An  
Bord  
Pleanála

**Board Direction**  
**BD-003104-19**  
**ABP-303813-19**

The submissions on this file and the Inspector's report were considered at a Board meeting held on 21<sup>st</sup> May 2019.

The Board decided to grant permission generally in accordance with the Inspector's recommendation, for the following reasons and considerations, and subject to the following conditions.

Drawing file: House Types / 1725-PL2-191 House Type J Floor Plans and Elevations.pdf

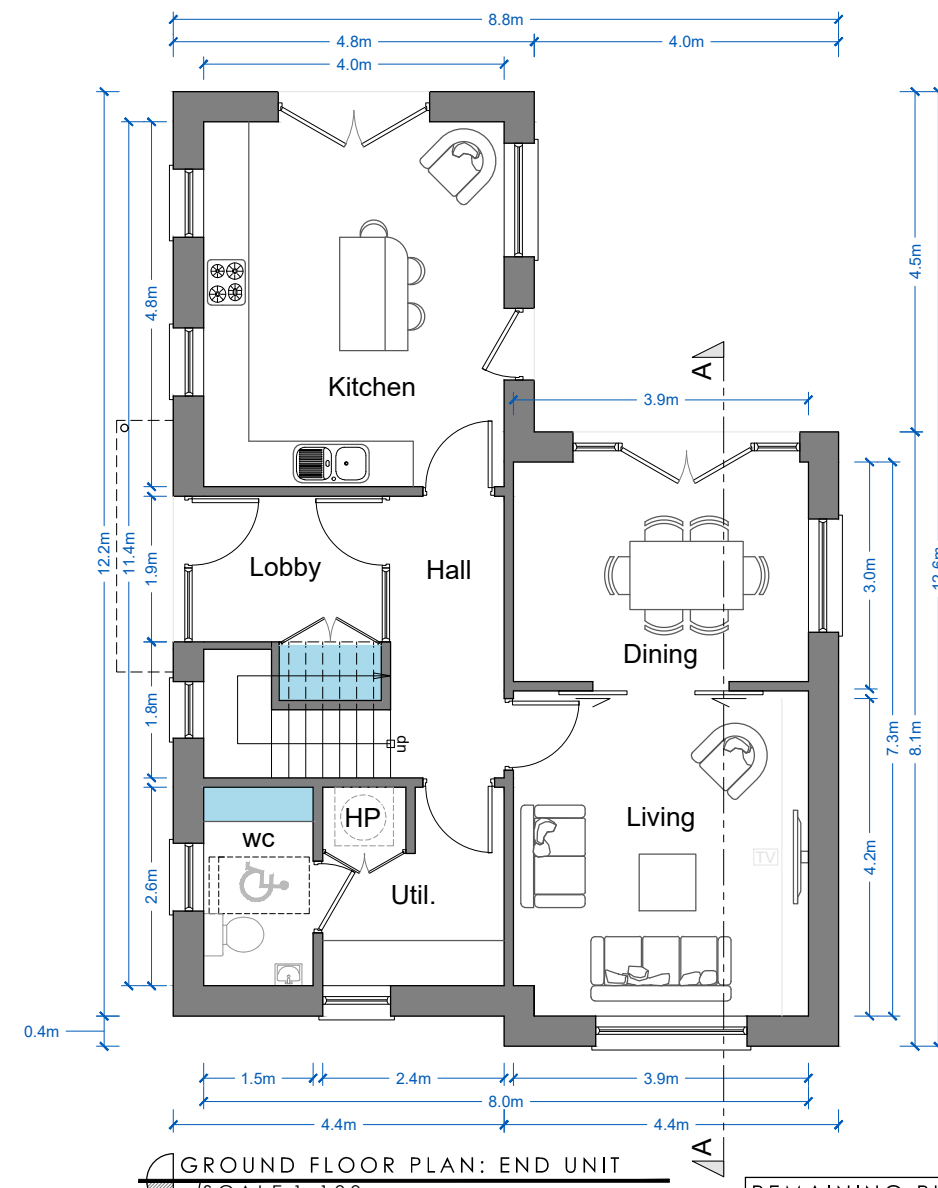
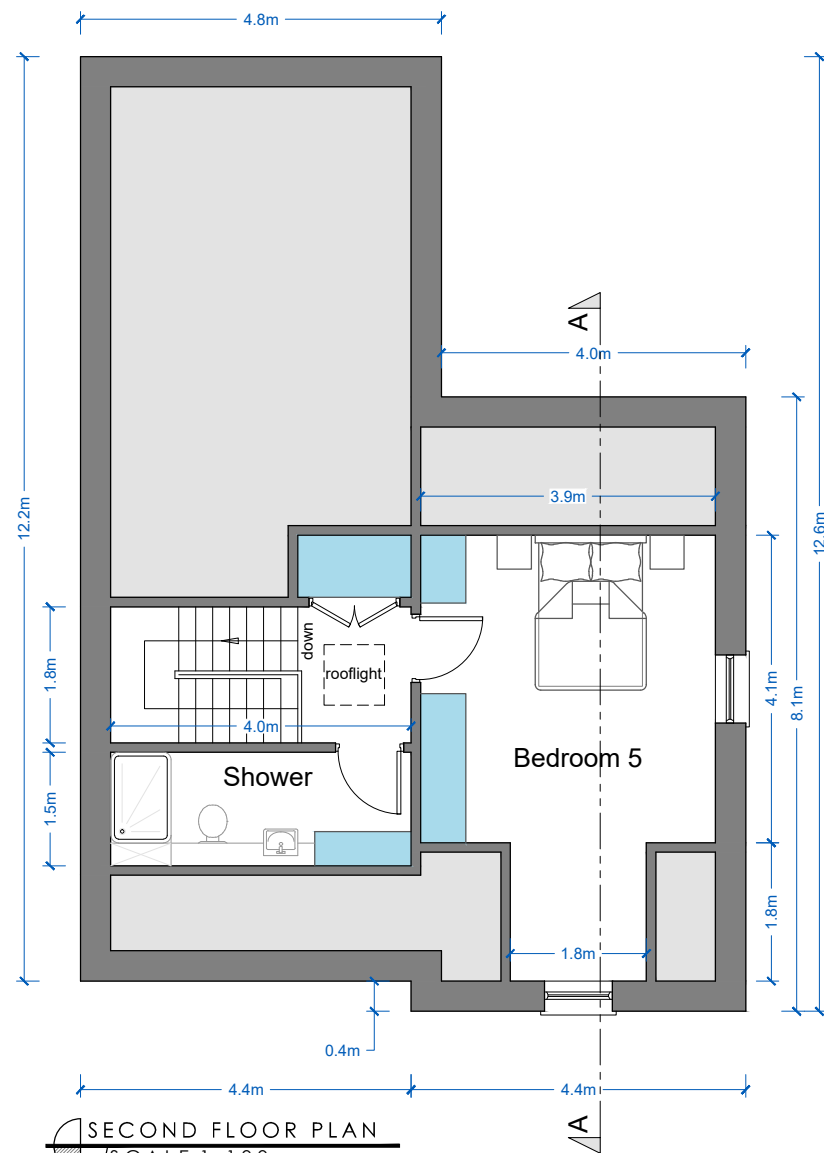
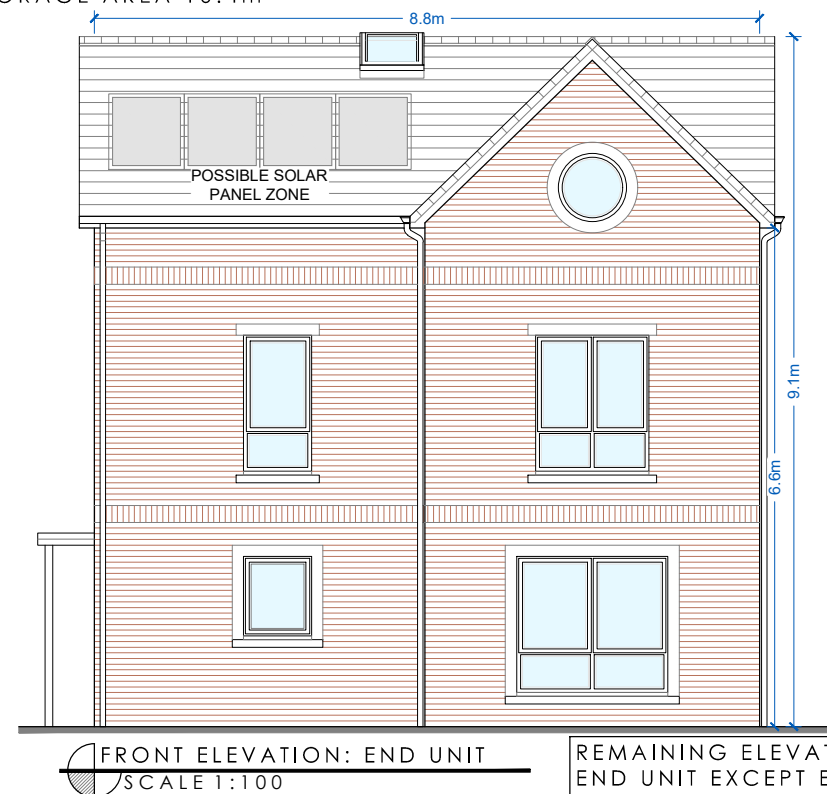
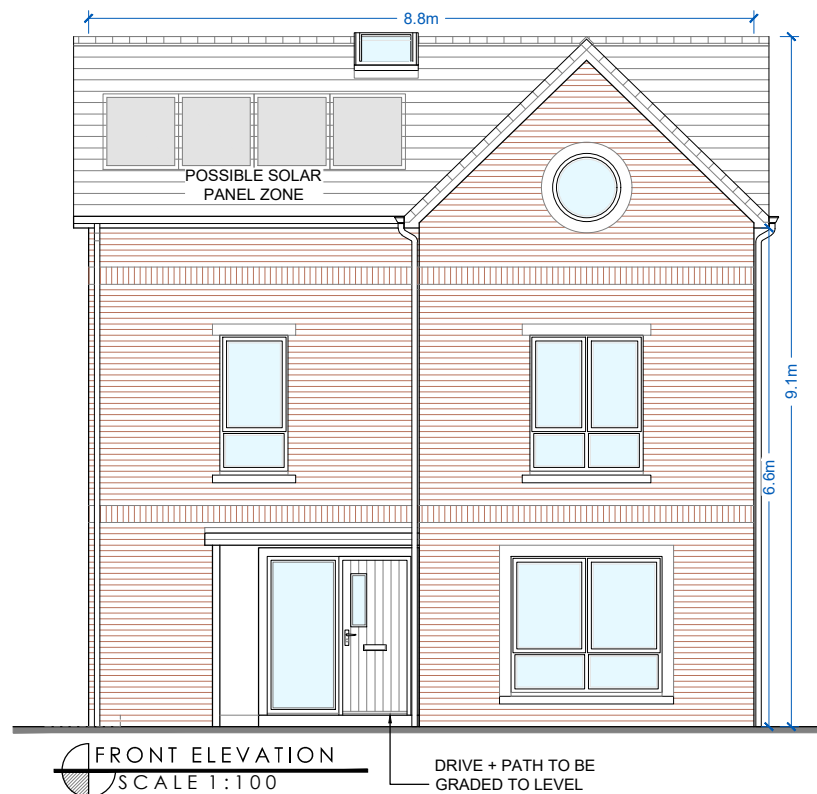
4. The proposed development shall be amended as follows:-
  - (a) The proposed semi-detached type C houses on plots numbers 125 and 126 shall be omitted, and shall be replaced by a single detached house type, of Type J, of the “end unit design” as indicated on drawing numbers PL2-191 and PL2-192, with dual frontage, including entrance door and windows facing towards the proposed future pedestrian route, and with a set-back front building line the same as the proposed Type J house on plot 133.

Revised drawings showing compliance with these requirements shall be submitted to, and agreed in writing with, the planning authority prior to commencement of development.
